Comment for planning application 20/02060/F

| Application Number | <input type="text" value="20/02060/F"/> |
| Proposal | <input type="text" value="Change of use of land to a mixed use for the keeping of horses (existing) and as a residential caravan site for 4no gypsy families. Each with two caravans (including no more than 4no static caravans / mobile homes) together with the laying of hardcore."/> |

DRAWING N° PBA 3

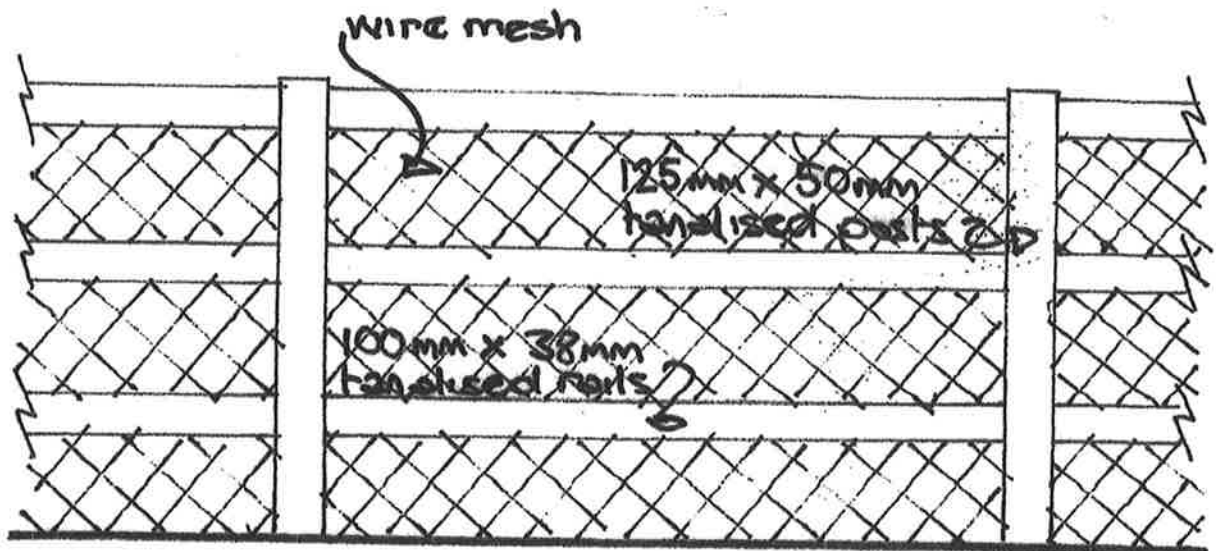
| Comments | <input type="text" value="Obstructs a right of way. It will ruin the landscape. No lighting in the area so it will be unsafe for any pedestrian to and from the site. The land will be more inclined to flood."/> |
